2023/0825

152 Barugh Lane, Barugh Green, Barnsley, S75 1LL

Erection of 1 no. dwelling and associated works (Outline seeking approval over layout and means of access)

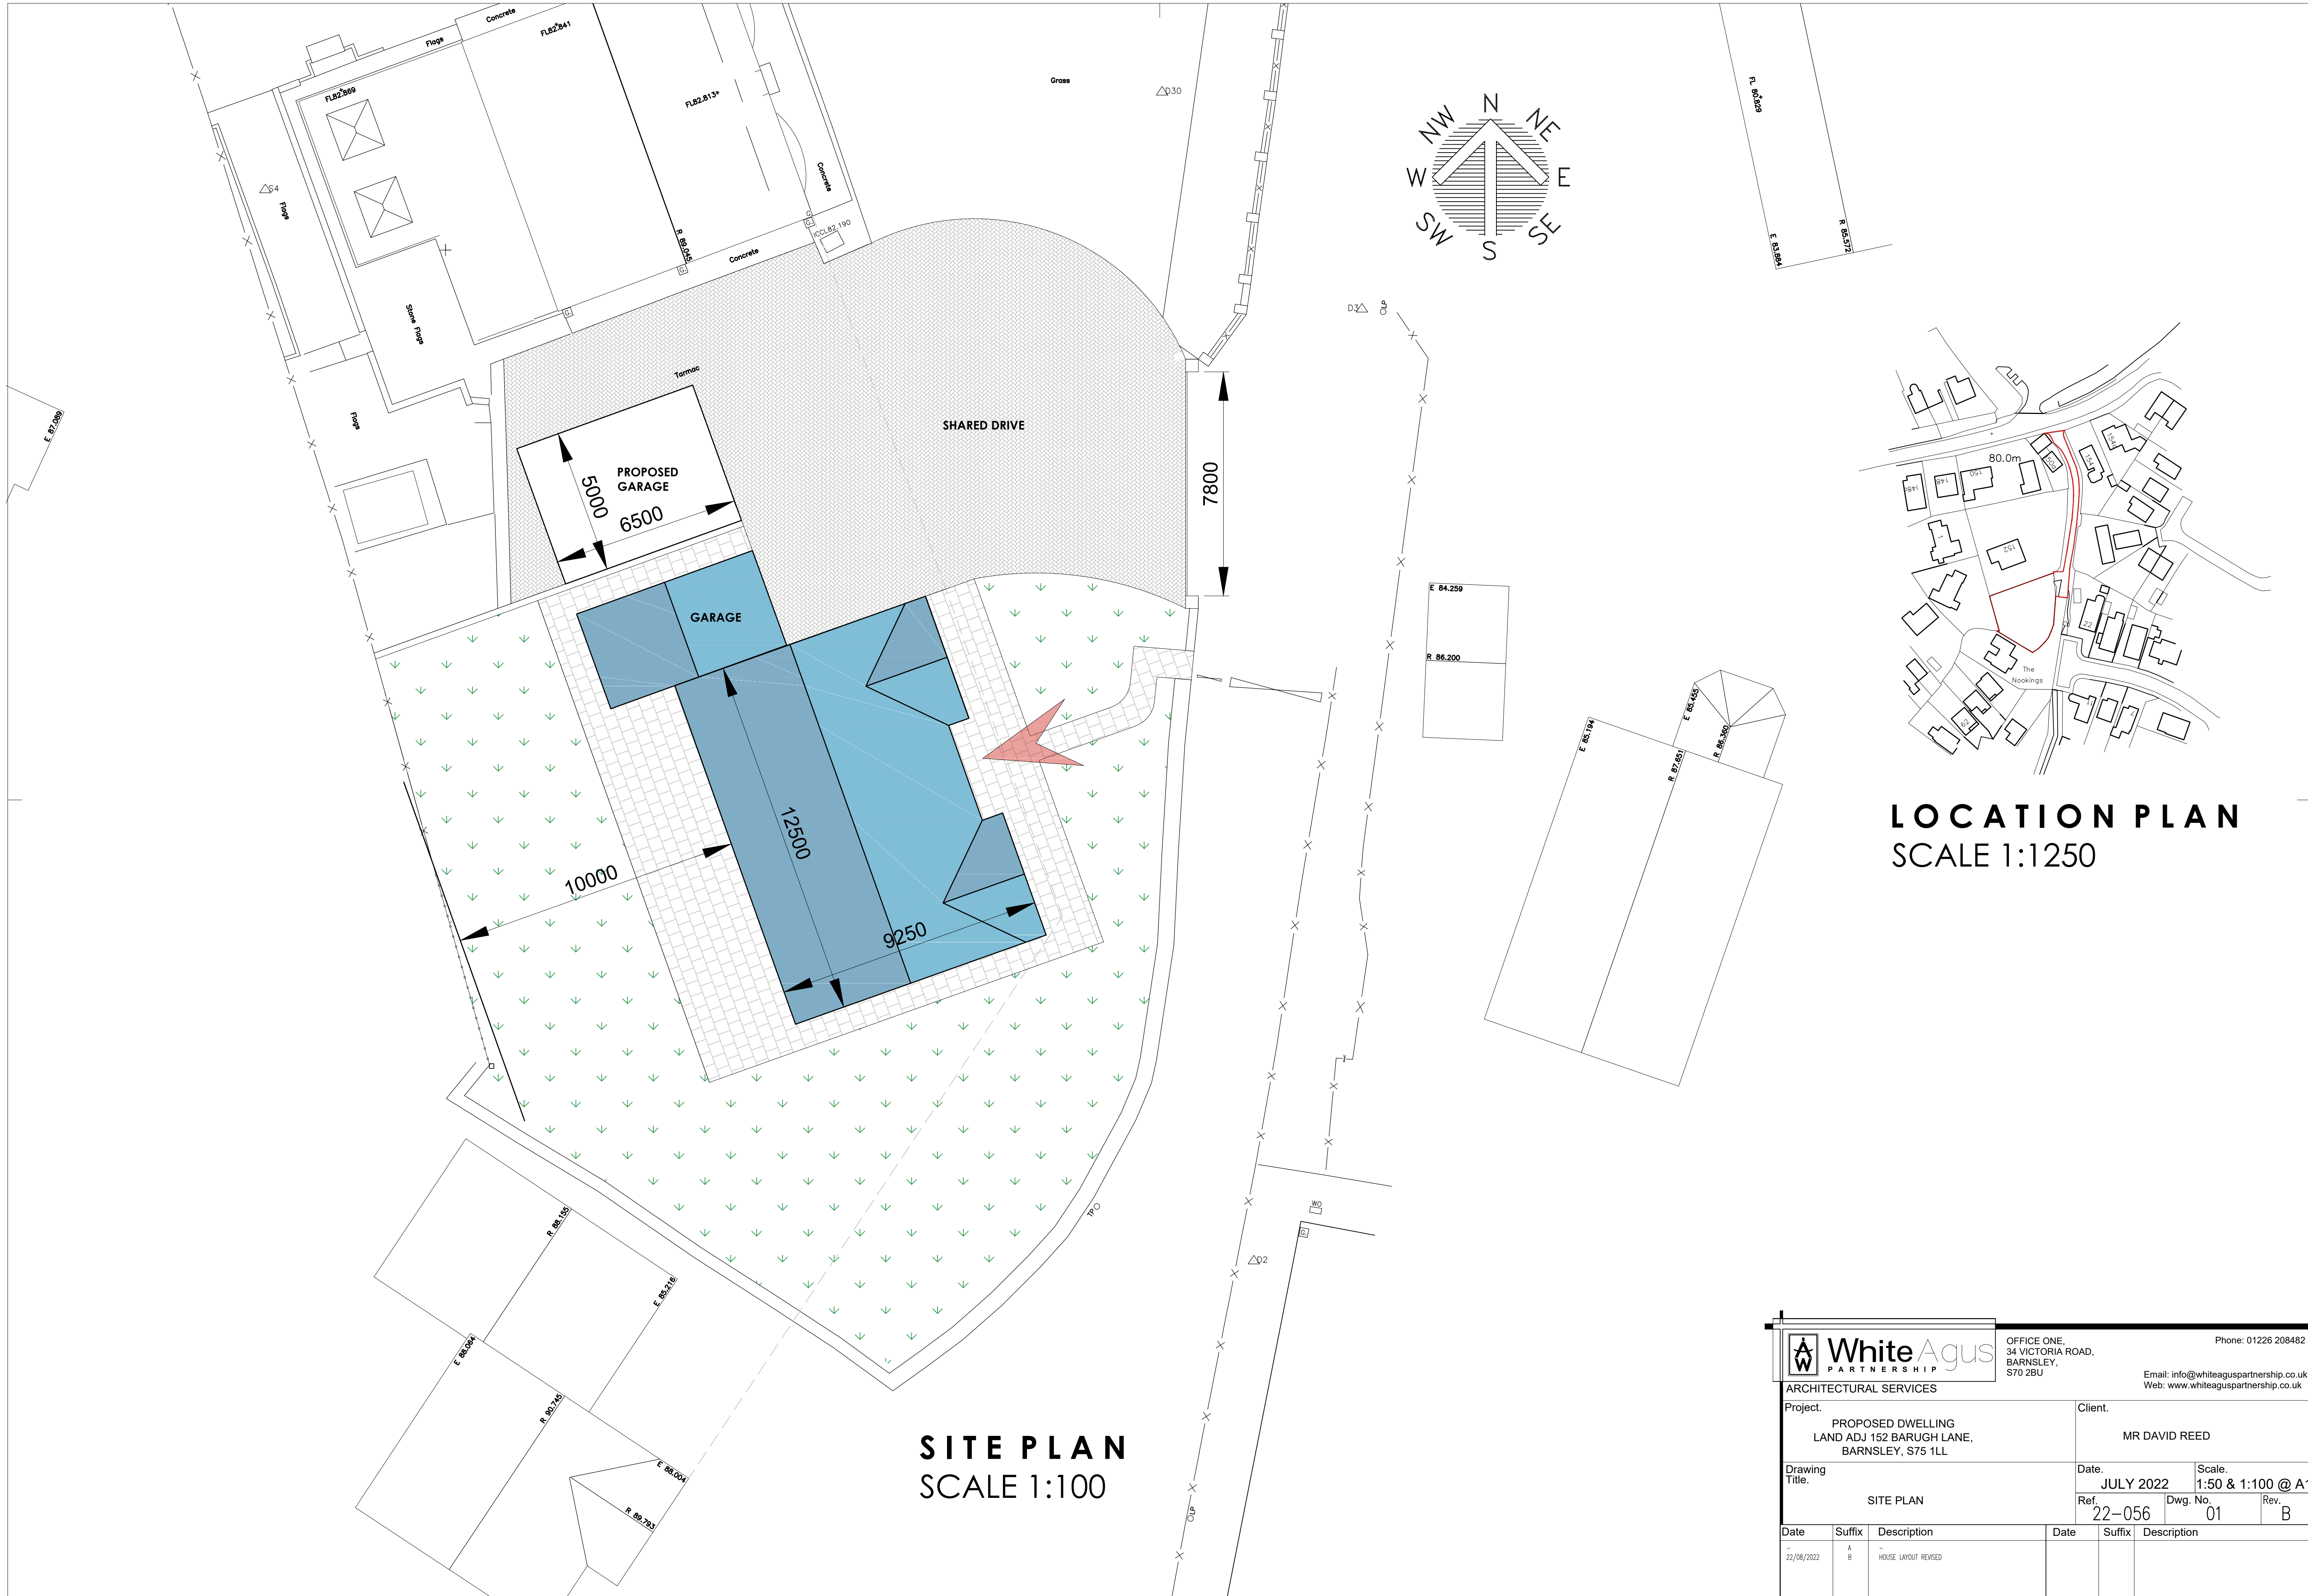
Only the means of access and layout are being considered at this stage, with a site plan showing the presence of a detached dwelling located centrally within the plot. No elevation drawings have been submitted which indicate that the dwelling will be single storey or greater, however the site plan shows separation distances in relation to neighbouring properties. The rear elevation of the dwelling is 10 metres from the rear boundary which is in line with the SPD for Design of Housing Development for the distance expected from first floor habitable room windows and rear boundary lines.

The front elevation of the dwelling (facing East) faces onto what appears to be the frontage of a neighbouring property (Que Sera, 22 Eden Close) at a distance of 16.5 metres which is in excess of the minimum 12 metres expected between habitable room windows and side elevations. At this stage, the submitted plans demonstrate that a single dwelling could be accommodated on the site which meets the adopted guidance and in respect of the layout of development in terms of the impact on the neighbouring properties and the proposed development is in compliance with Local Plan Policy GD1 and the SPD for Design of Housing Development and is acceptable in terms of residential amenity.

The proposed development is an outline permission with details of layout and means of access to be considered. No floor plans or elevation drawings provided at this stage. As such, a full assessment has not been taken as to the design/visual amenity of the development however a site plan has been submitted which shows a dwelling which is located centrally within the plot and is of a size which is proportional to the site and is acceptable in terms of overall layout and shape. It is considered that a single storey dwelling would be most appropriate on this site due to character of surrounding dwellings and topography, and a condition is proposed.

To the North of the dwelling is a shared parking area which appears to be hard surfaced on the plan but is not specified. In any case, a condition can be attached to any approval notice which ensures the parking area to be hard surfaced which is required from a design perspective. Likewise, boundary treatments and external materials will be covered through a pre-commencement planning condition.

Drawing 151762-003

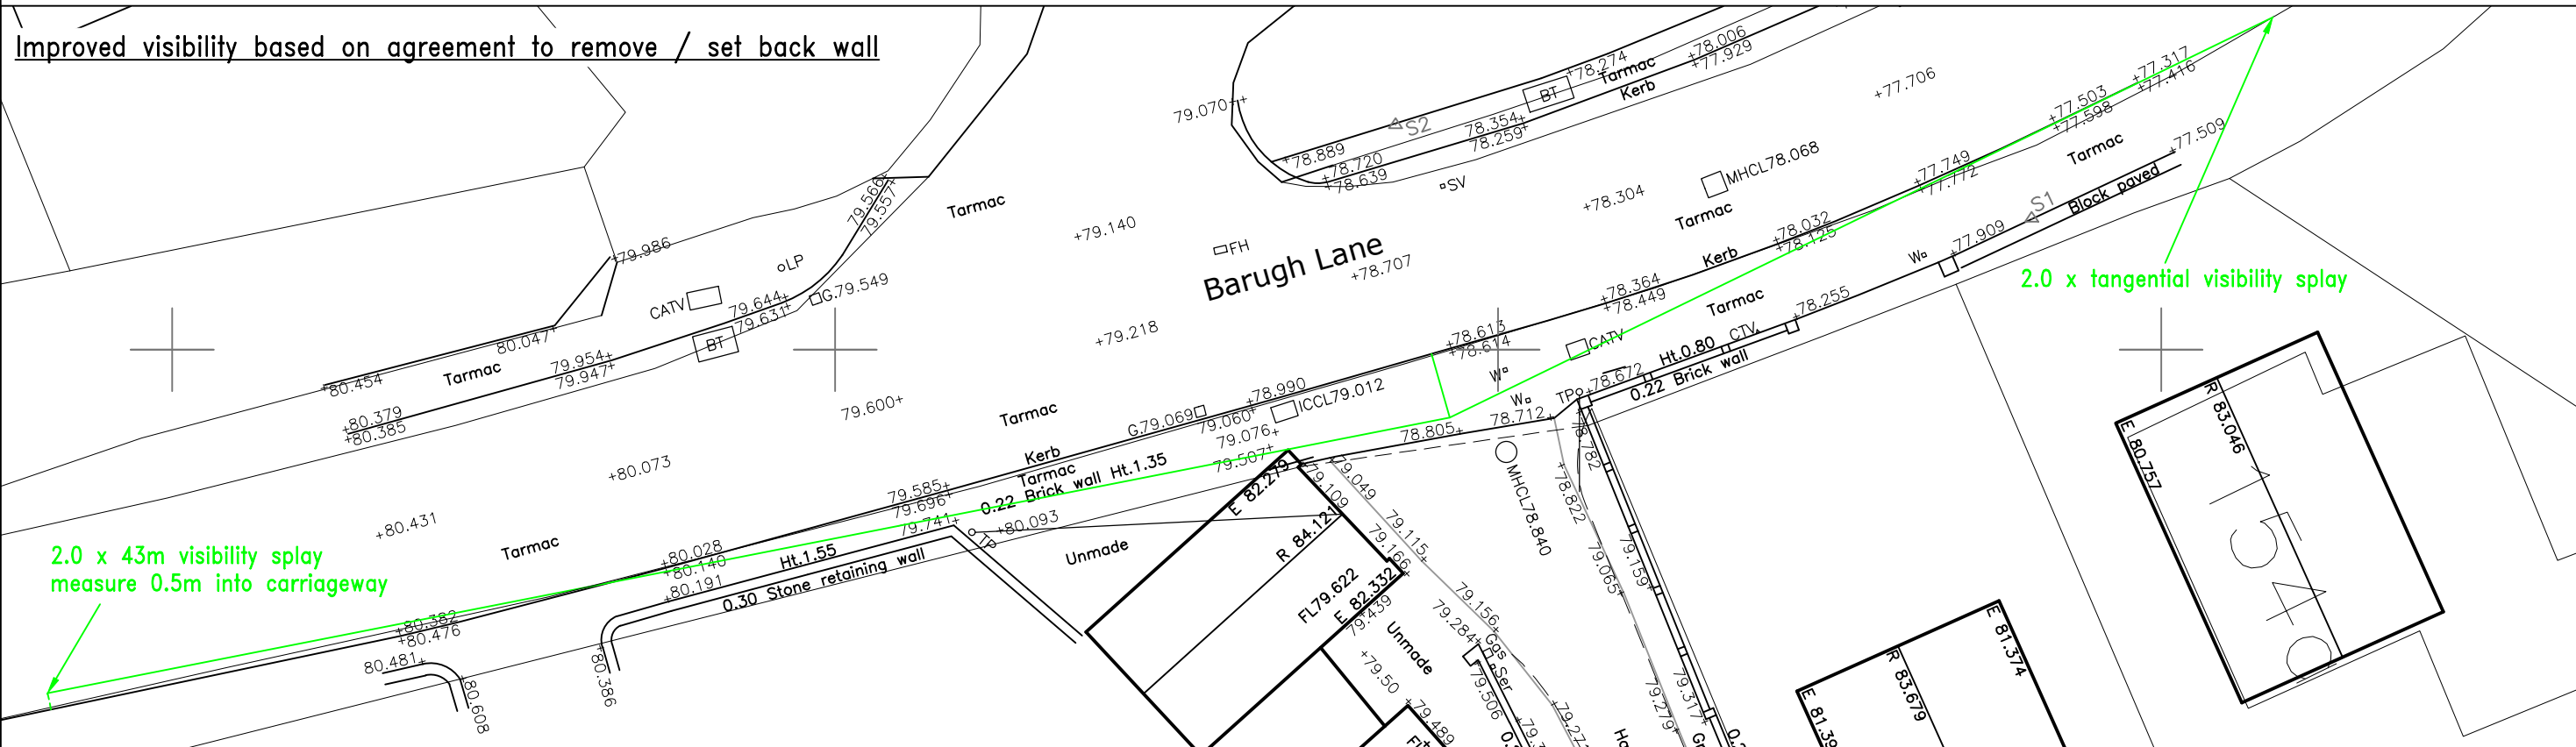
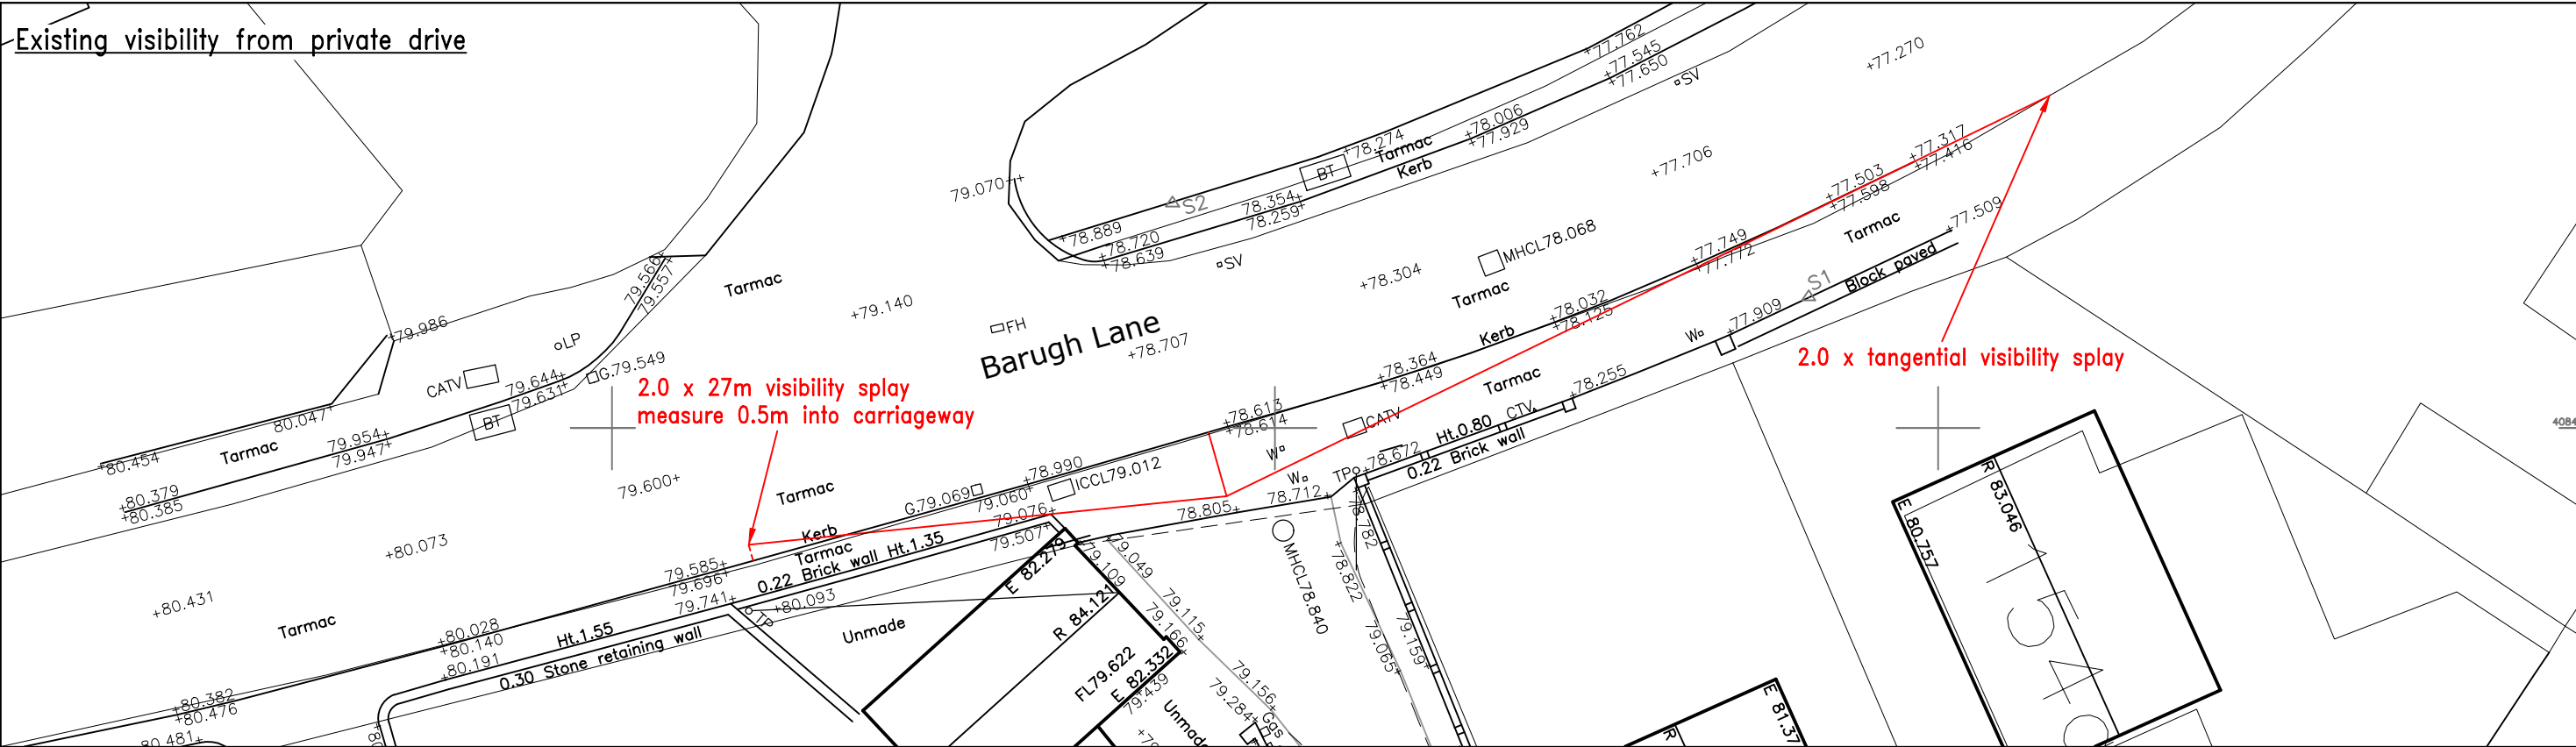
It has been stated within the submitted information that the applicant has reached an agreement that the boundary wall adjoining the garage adjacent to property no.150a at the access track junction with Barugh Lane can be removed in order to improve visibility. With this wall removed, visibility to the left (West) improves from approx. 2.4m x 10m to approx. 2.4m x 18m (with the 'y' distance

measured 0.5m into the carriageway). This equates to a significant improvement of around 80% and although this is still well below the standard required, such an improvement would obviously benefit all users of the access track.

Although it has been determined that an 'x' distance of 2.0m is not suitable in this location, it is worth mentioning that, with the wall removed, visibility to the left would improve from approx. 2.0m x 14m to approx. 2.0m x 43m (with the 'y' distance measured 0.5m into the carriageway). This highlights that an even greater improvement would be provided at the point where vehicles start to 'nose' out into the nearside carriageway of Barugh Lane. With the above in mind, on balance it is considered that the improved visibility, along with other access improvements, would be of sufficient enough benefit to outweigh any adverse highways impact of the development.
